From: Katherine Rawlins
Sent: 13 January 2012 14:34
To: [REDACTED]
Subject: RE: P/51/11 Extension, alteration and new detached garage 7 Webb Close Pagham

Thank you for the amended plans and proposals for No. 7 Webb Close.

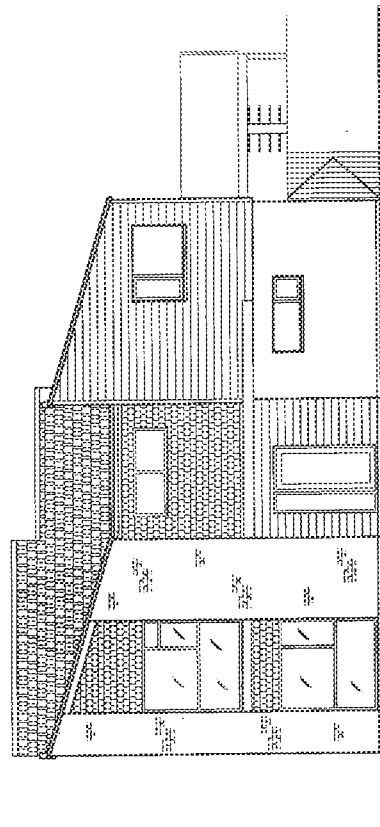
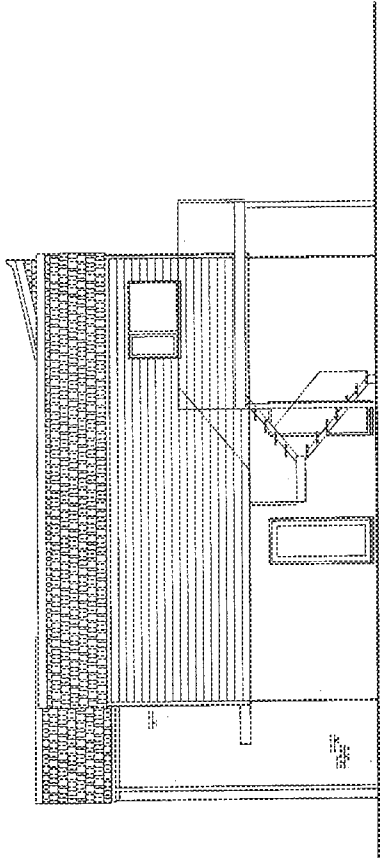
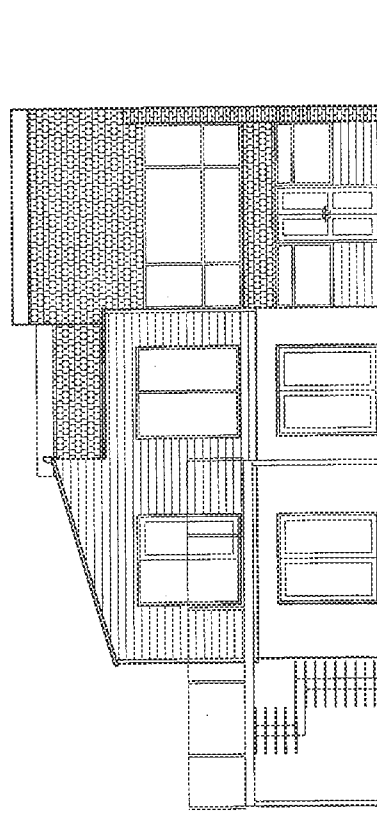
Having reviewed the plans, the addition of the mono pitch roof over the extension is considered to be an improved in design terms from the original scheme. This echoes the distinct character and appearance of this row of terraces.

However, I note the choice of materials of render and horizontal cladding, which does not reflect those of the main dwelling (yellow brick and tile hanging). Please could you explain the choice of materials?

First floor

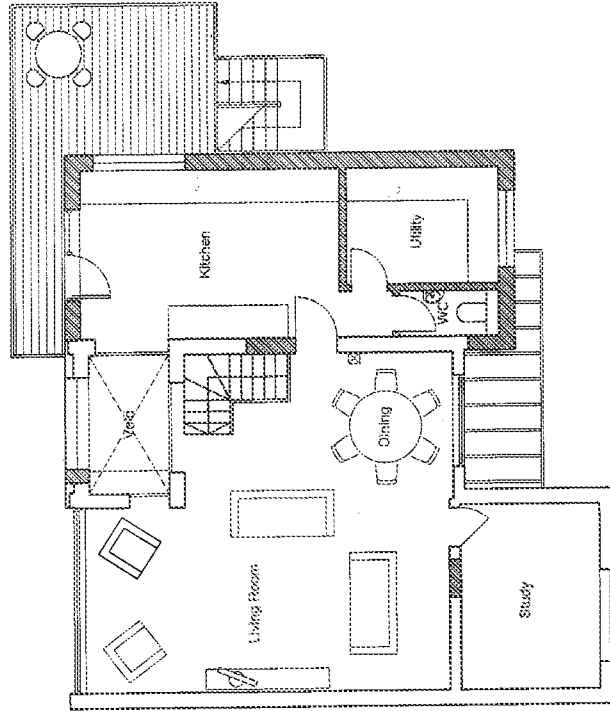
I note the omission of the detached garage and the re-positioning of the balcony to the side with rearward projection of 1 metre. I do have concerns regarding the rear projection of the balcony, even at this reduced depth, given the change in levels and the impact on the property at the rear, which is a bungalow. I would therefore suggest that the balcony is re-positioned entirely to the side and that a privacy screen is provided to prevent any overlooking.
